From: Jodie Wilkes [REDACTED]
Sent: 12 September 2017 16:43
To: Planning.Responses
Cc: Gary Markwell
Subject: Highways Response LU/249/17/PL

SUBJECT: LU/249/17/PL- Demolition of the existing bungalow & redevelopment of the site with 5 No. detached houses. This application is a Departure from the Development Plan.

Directors Cottage, Toddington Lane, Wick, Littlehampton, West Sussex, BN17 7PP

Drawing: **LOCATION, STREET SCENE & EXTERNALS**

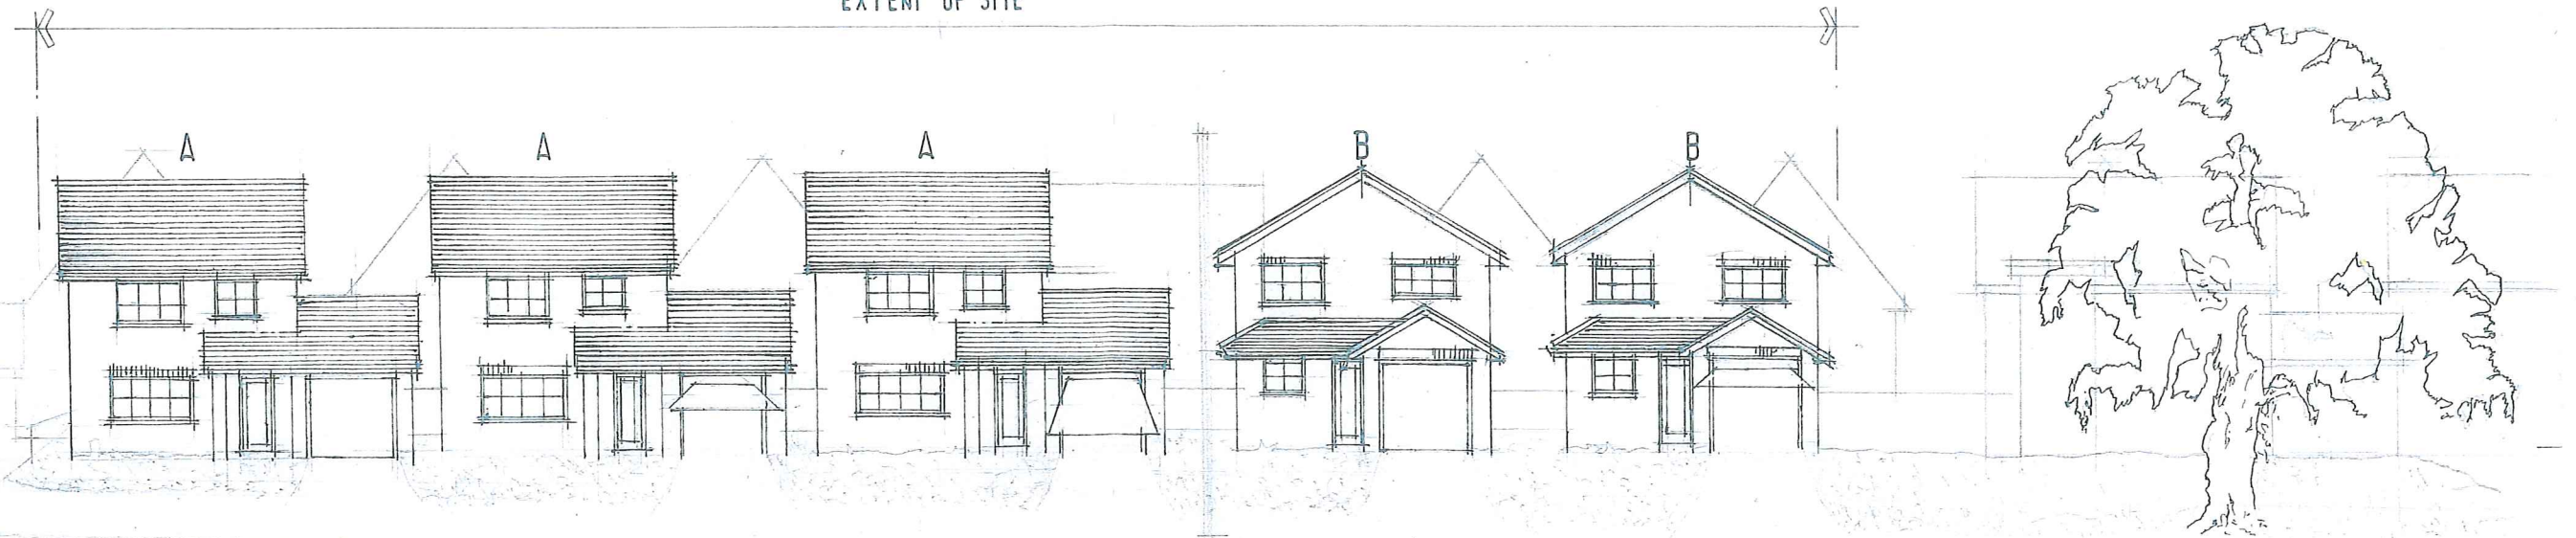
There are no initial concerns with the indicative layout. The accesses are to measure 3m each in width, this is considered suitable as this will be a low speed, low traffic environment. The parking allocation is in accordance with the demand from the WSCC PDC (Parking Demand Calculator). From checking this and based on the proposed mix and tenure of the dwellings, the car parking provision is anticipated to satisfy the likely demands. Garage spaces measure 3m x 6m in accordance with WSCC specifications.

A turn on site would be preferred, clearly though there is insufficient space to achieve this. Other properties closer to Mill Lane have similar arrangements and are operating with no known highways safety concerns.

Secure covered cycle parking has been proposed for this development- this too is advised to be sealed via planning condition should permission be granted.

The dropped crossings must be implemented under licence to a specification obtained from WSCC Highways.

The speed limit on Toddington Lane is 30mph therefore manual for streets standards can be adopted for SSD (Stopping Sight Distances) and splays of 2.4 x 43m would be required at these accesses. The splays appear to be achievable wholly within the Highway Boundary, therefore visibility splays will be required to be conditioned alongside any permission of this application and maintained to below a height of 0.6m above the carriageway height.

No part of the development shall be first occupied until visibility splays of 2.4 metres by 43m metres have been provided at the proposed site vehicular access onto Toddington Lane in accordance with plans and details submitted to and approved in writing by the Local Planning Authority. Once provided the splays shall thereafter be maintained and kept free of all obstructions over a height of 0.6 metre above adjoining carriageway level or as otherwise agreed.

No part of the development shall be first occupied until such time as the existing vehicular access onto Toddington Lane has been physically closed in accordance with plans and details submitted to and approved in writing by the Local Planning Authority.

No part of the development shall be first occupied until such time as the vehicular access serving the development has been constructed in accordance with the approved drawing.

No part of the development shall be first occupied until the car parking has been constructed in accordance with the approved site plan. These spaces shall thereafter be retained at all times for their designated purpose.

No part of the development shall be first occupied until covered and secure cycle parking spaces have been provided in accordance with plans and details submitted to and approved by the Local Planning Authority.
